ENG-PUDSP19011-R2-LOI-redlines Summary_Markup Summary

ENG-PUDSP19011-R2-PUDSP-redlines Summary_Markup Summary

ENG-PUDSP19011-R2-TIS-redlines Summary_Markup Summary

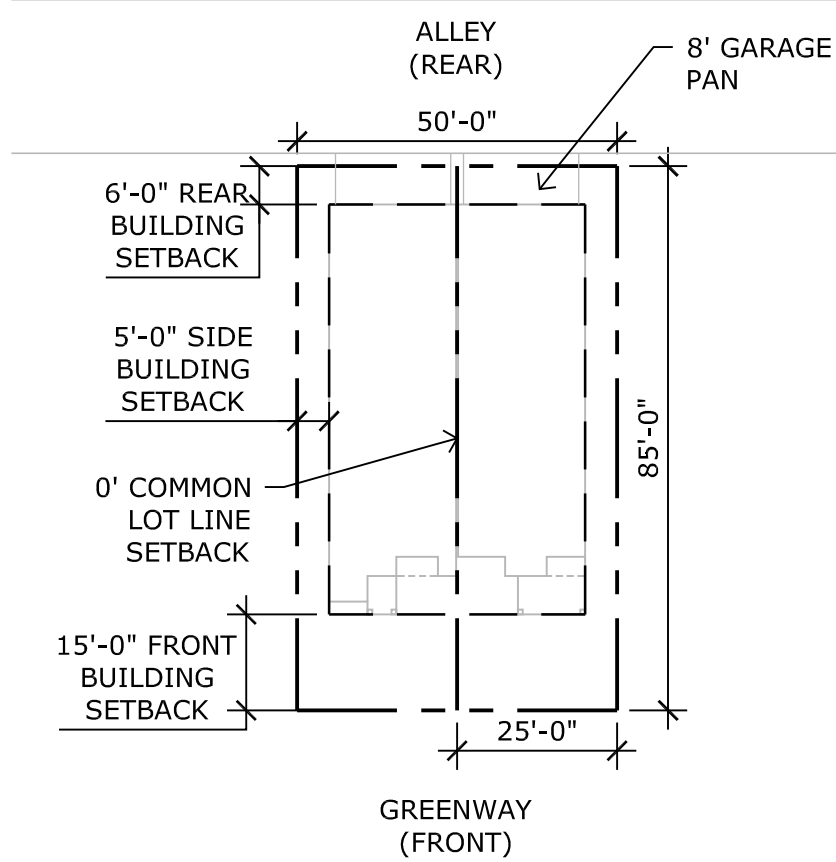
some allow for driveway parking per parking table

PUD PRELIMINARY
SITE PLAN

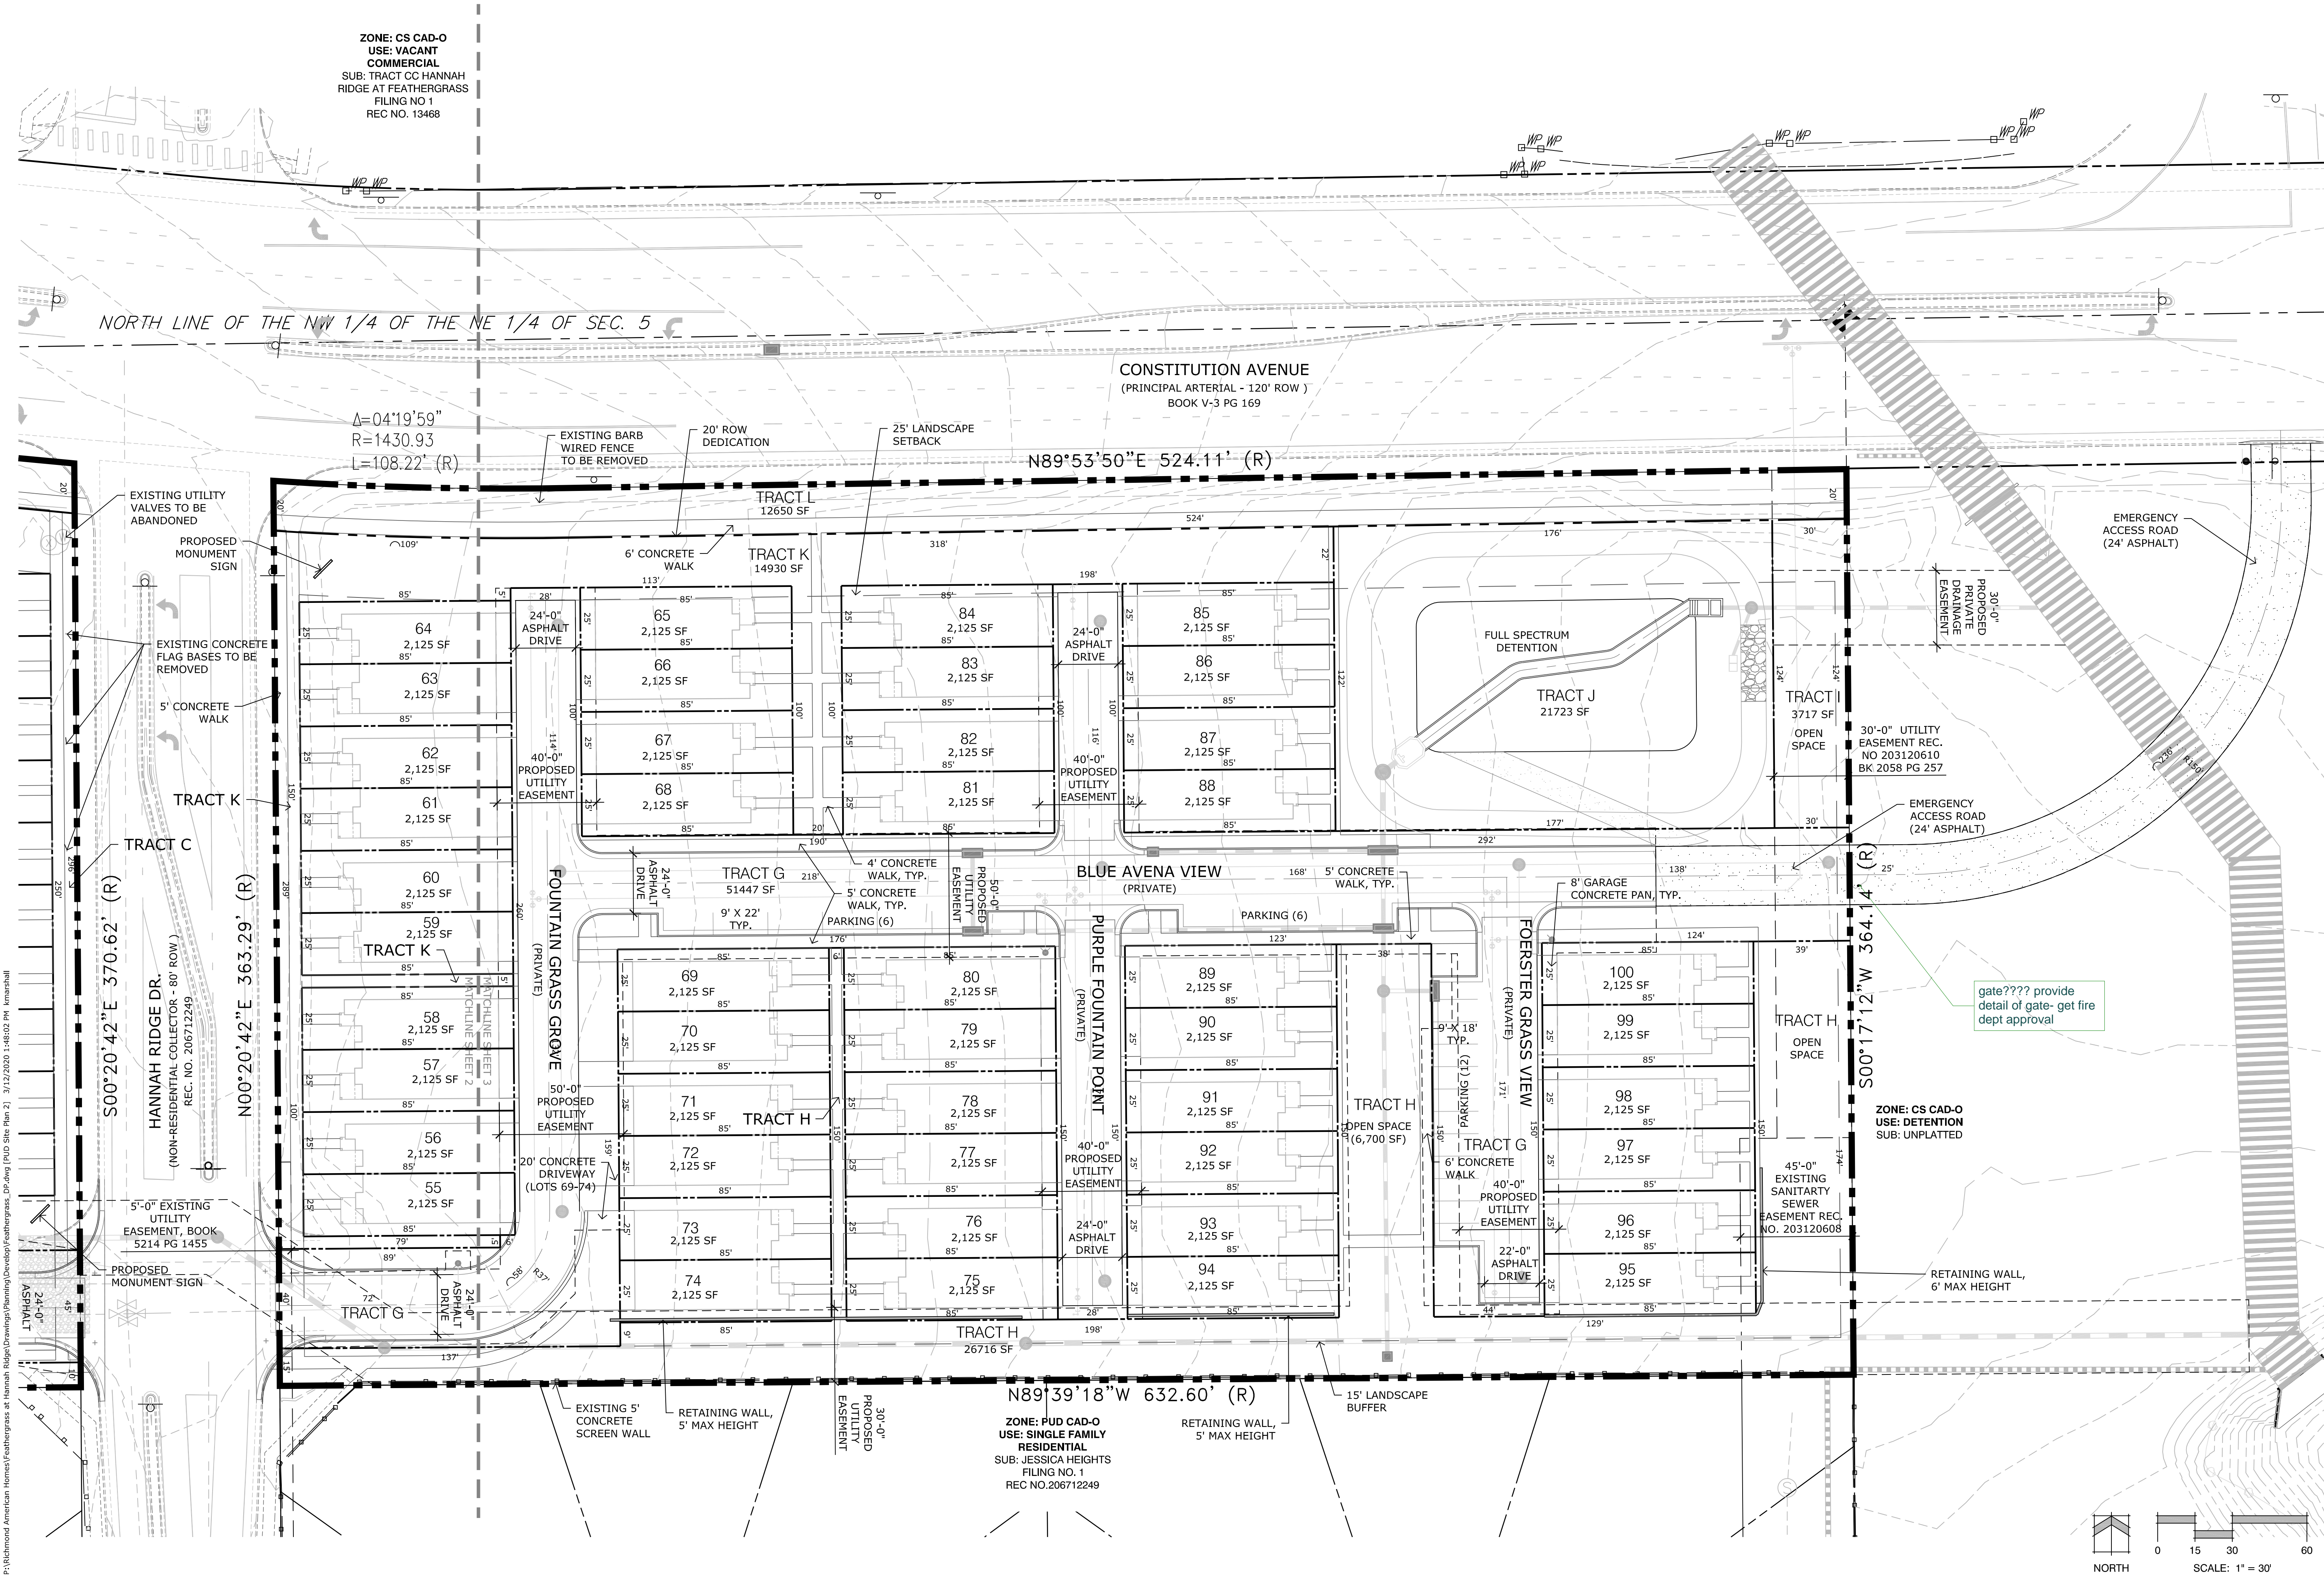
after noise study is updated to match current TIS, setbacks from Constitution may change... 2018 noise study data doesn't match TIS

add % openspace contiguous here and to LOI

total % open space-please add here and to the LOI so the BoCC sees that you have exceeded 10percent to support pud modifications

ADA Parking? ADD

depending on updated noise study-this could change

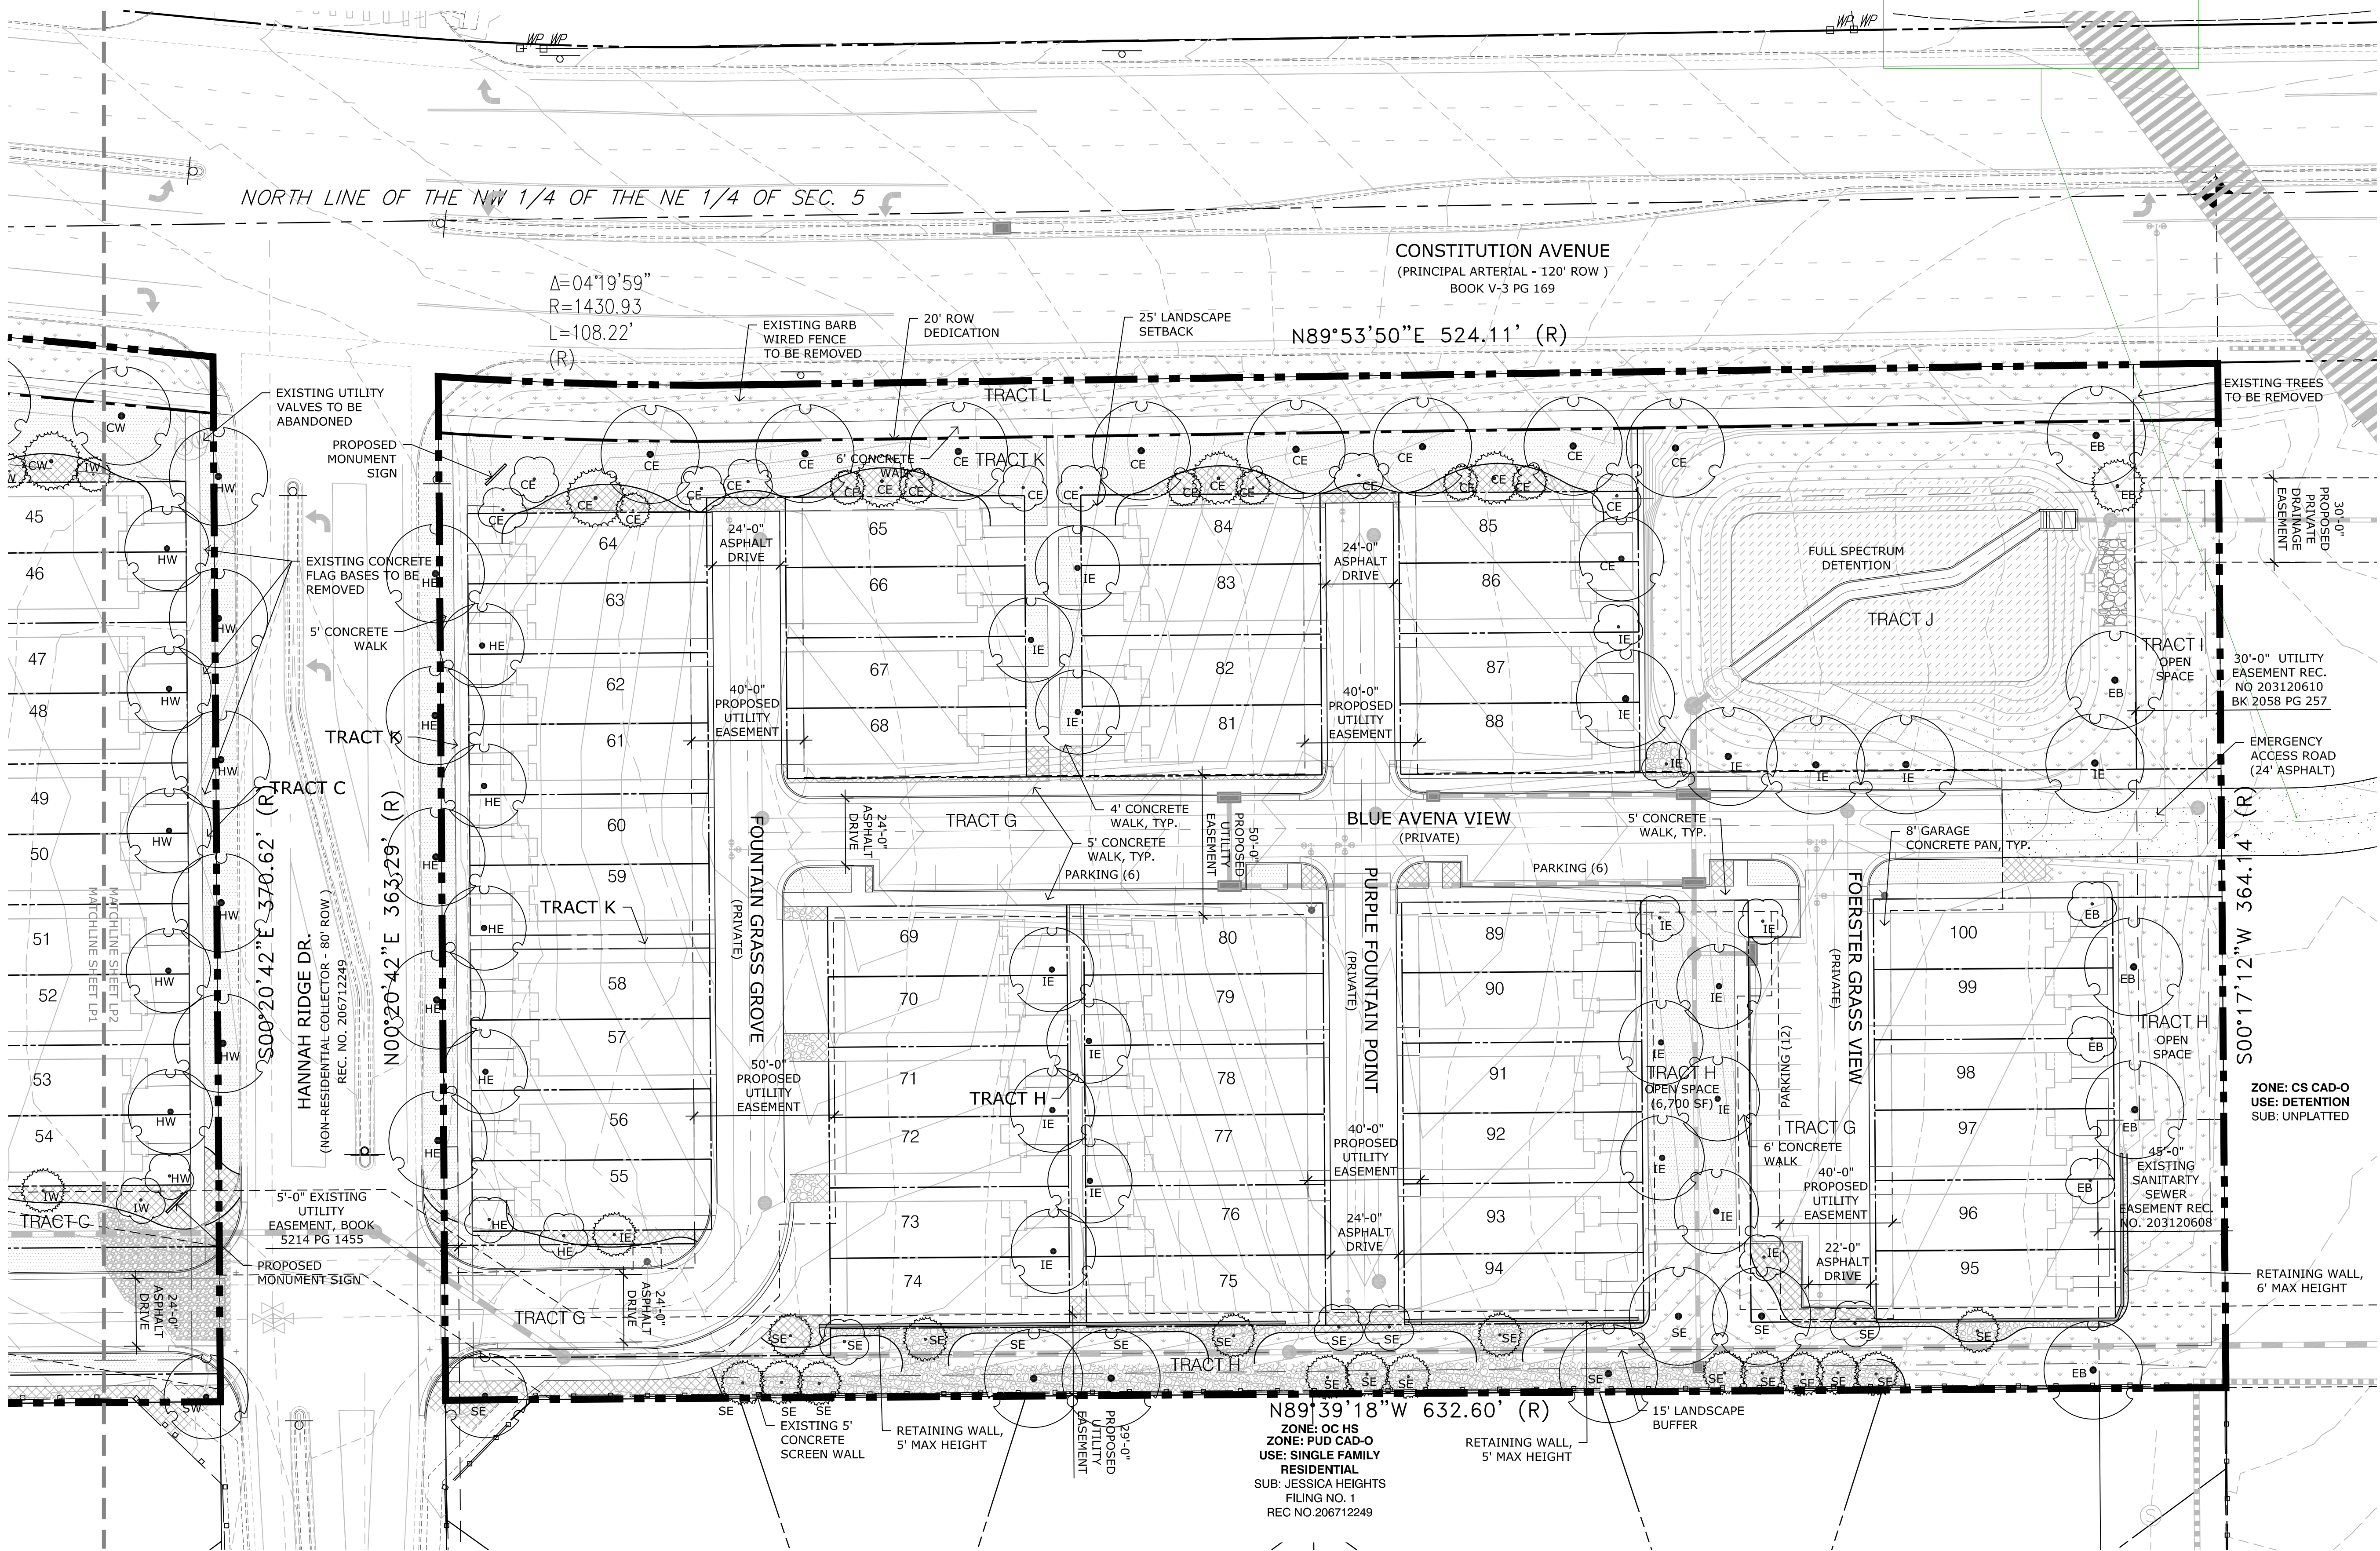
should we be escrowing money to construct the road that needs to be extended from the north? If we do not get some with this then the burden is on the adjacent property souley... provide detail of ow your closing this access for ER purposes only;
